11 May 2022

**RE: MOUNT PLEASANT OPERATION DA 92/97 – PROPOSED MODIFICATION TO RECTIFY AN ERROR**

**MOUNT PLEASANT OPERATION**

FIGURE 3 - APPROVED SURFACE DISTURBANCE PLAN

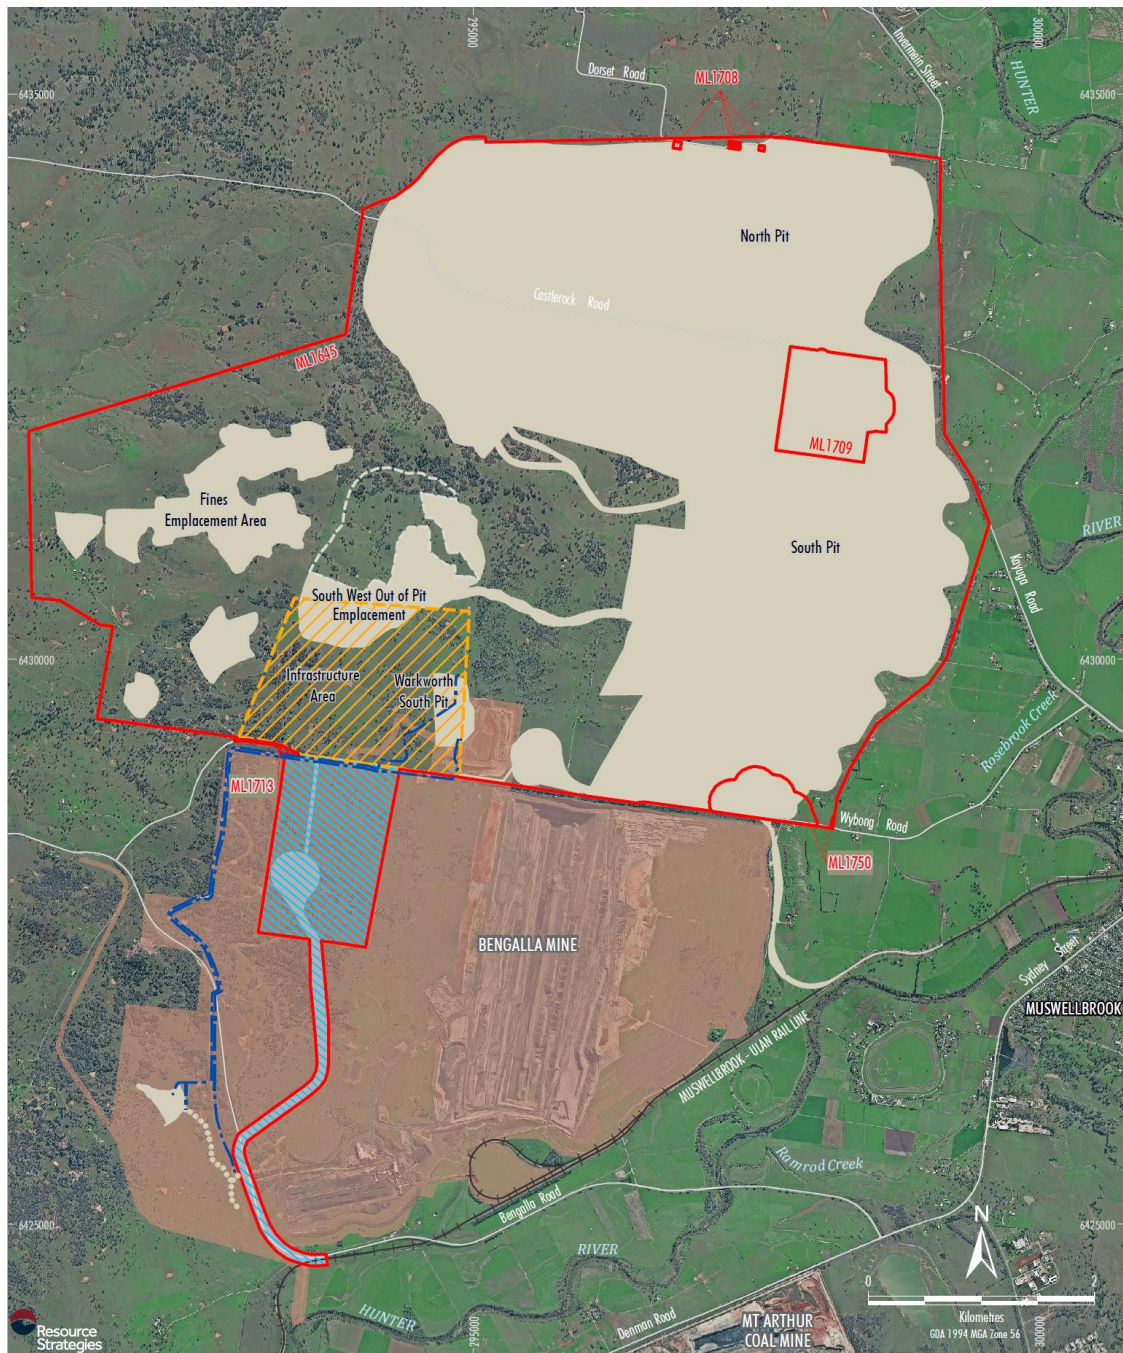
Modification 3 was subsequently approved by the Independent Planning Commission on 24 August 2019. The DW1 discharge dam and associated infrastructure was included on new Figures 1 and 2 of Appendix 2 of Development Consent (DA 92/97), but in an apparent oversight, was not shown on Figure 3 of Appendix 2 of the Consolidated Consent.

- Update Figure 3 in Appendix 2 to also include DW1 and the associated scour protection and pipelines (currently included on Figures 1 and 2, but not on Figure 3);
- Update the Definitions to include reference to MACH's letter of 15 February 2018 in the list of relevant EA (Mod 3) documents; and
- Update Appendix 1 (Schedule of Land) to include relevant additional lots listed above and associated diagram update.
